BOTLEY WEST SOLAR FARM

OXFORDSHIRE HOST AUTHORITIES RESPONSES FOR DEADLINE 3 | TUESDAY 22 JULY 2025

RESPONSES FOR DEADLINE 3

Illustrative Masterplan
Figure 5.3A: Cable Corridor Option A

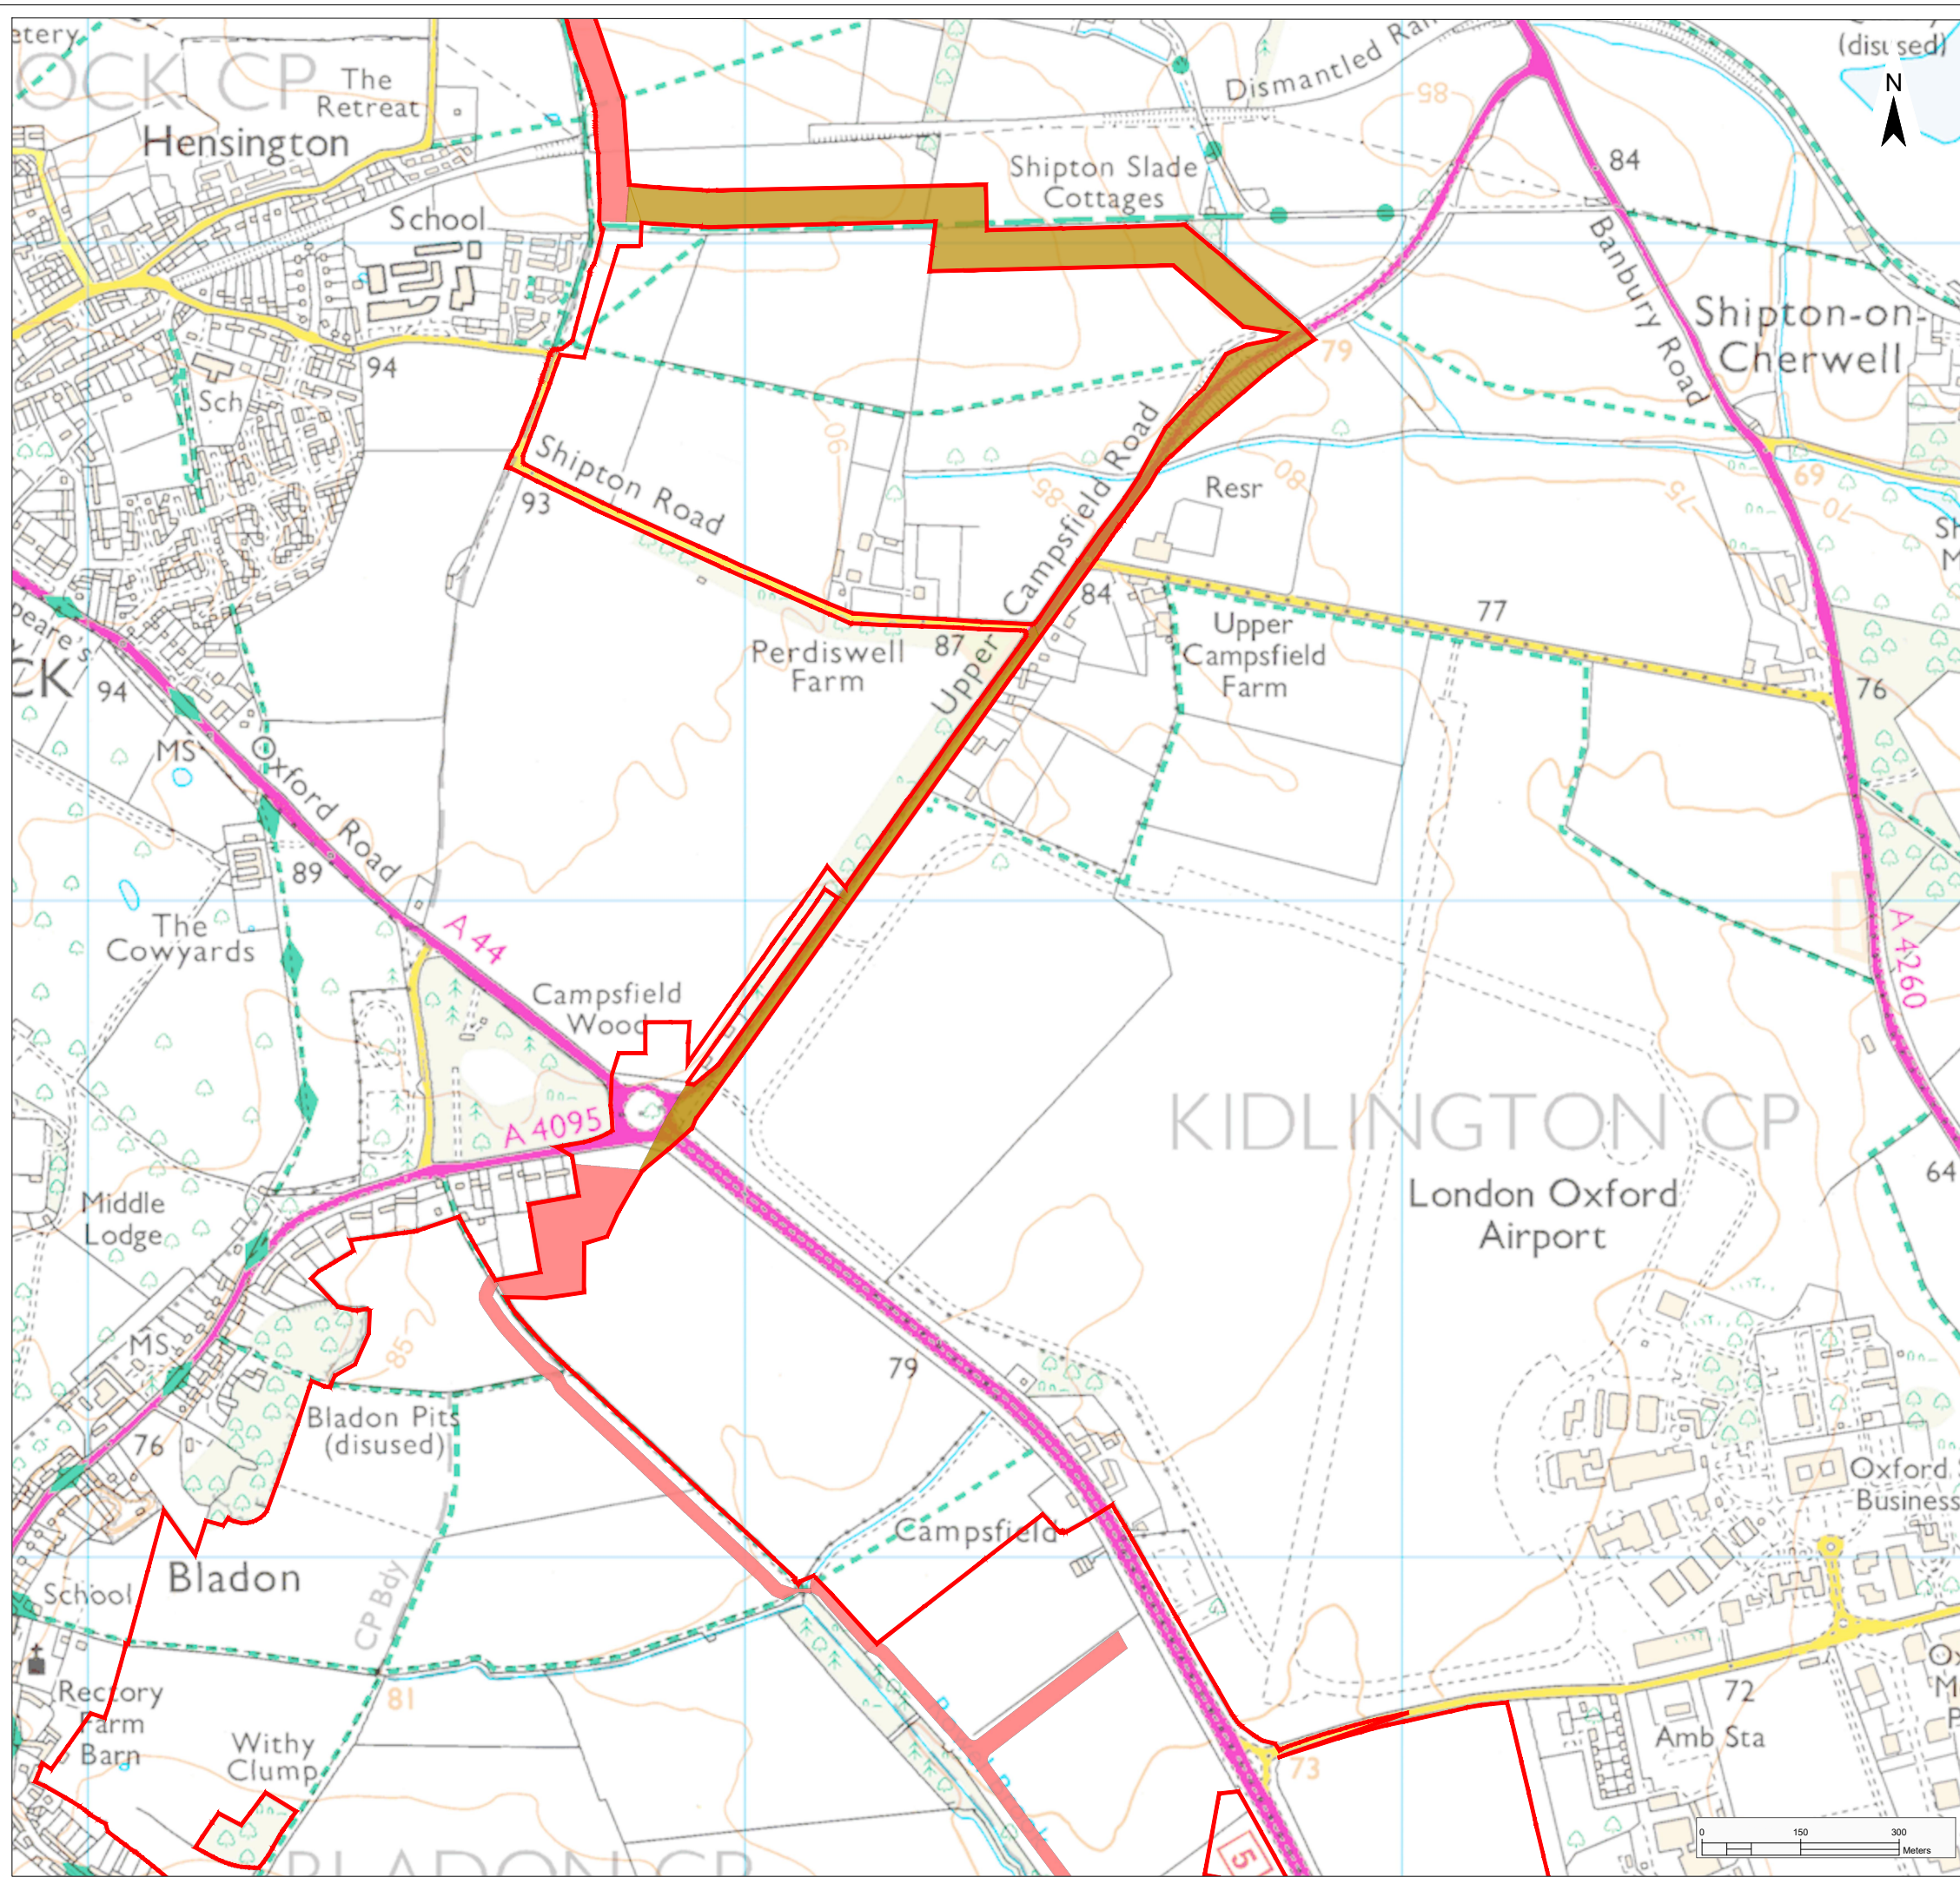
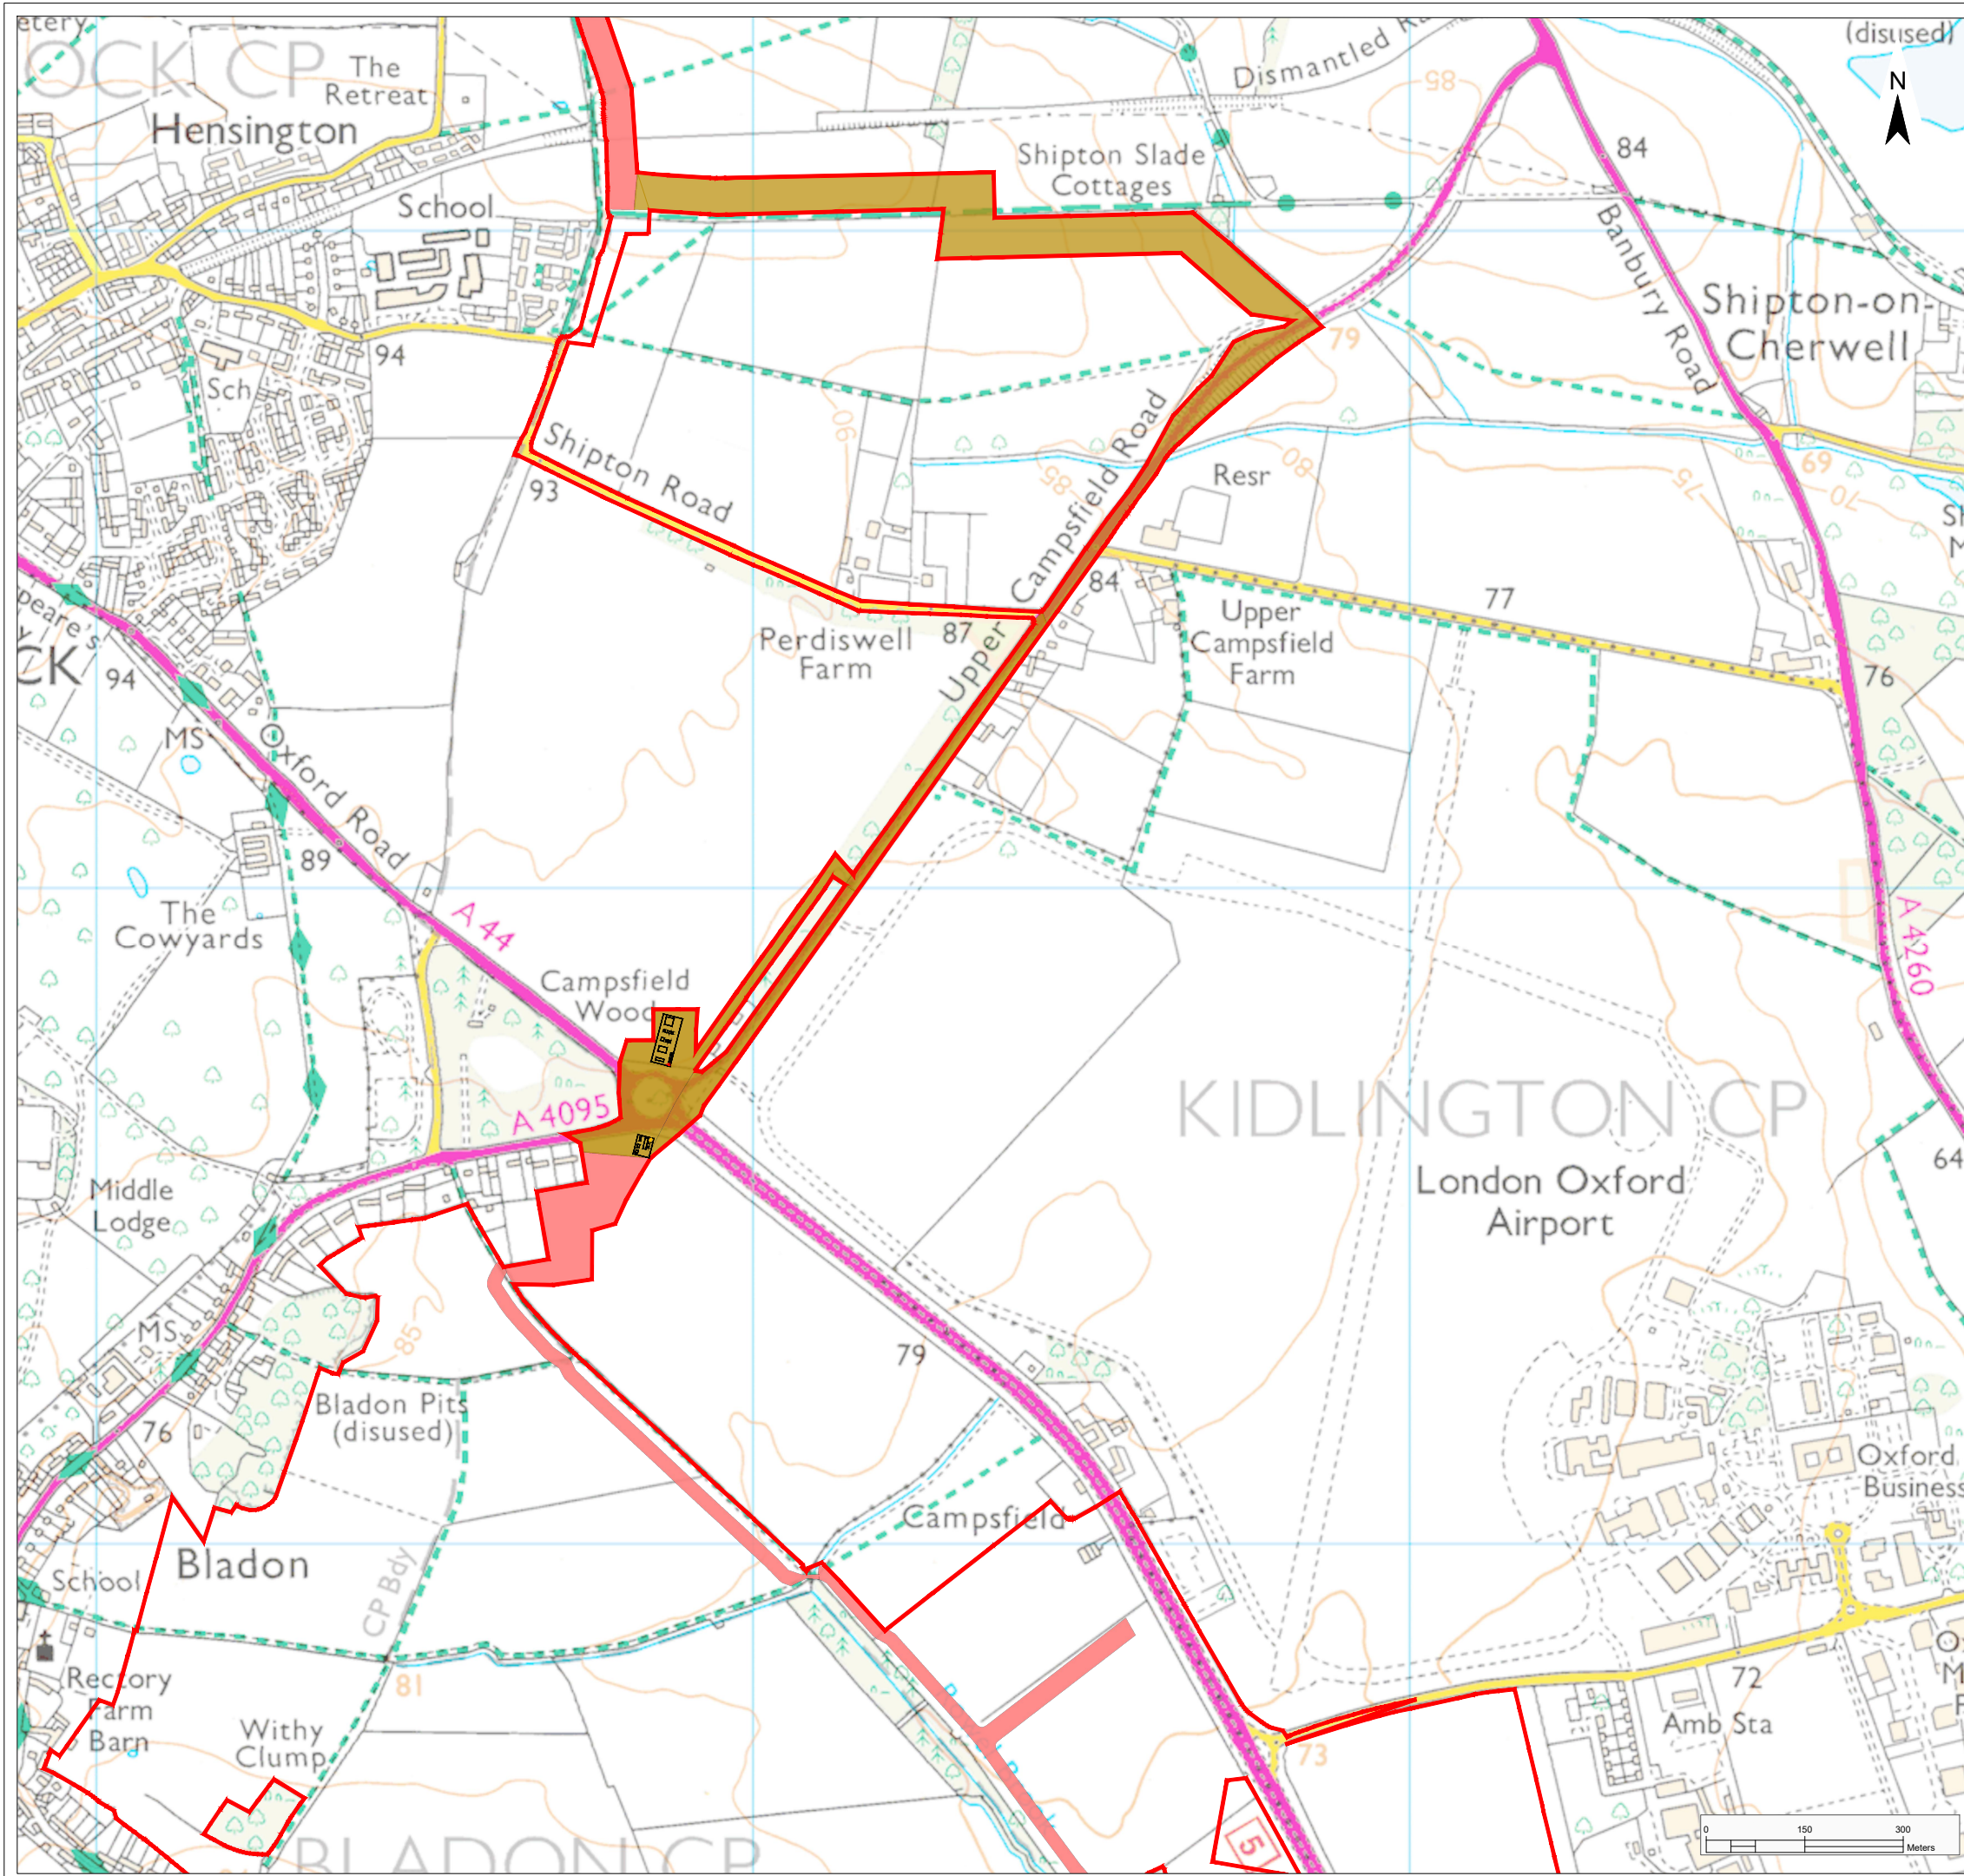
The Illustrative Masterplan suggests that such planting is currently not proposed, and the OHA requests that this is secured as part of the DCO process in liaison with the CNLB.
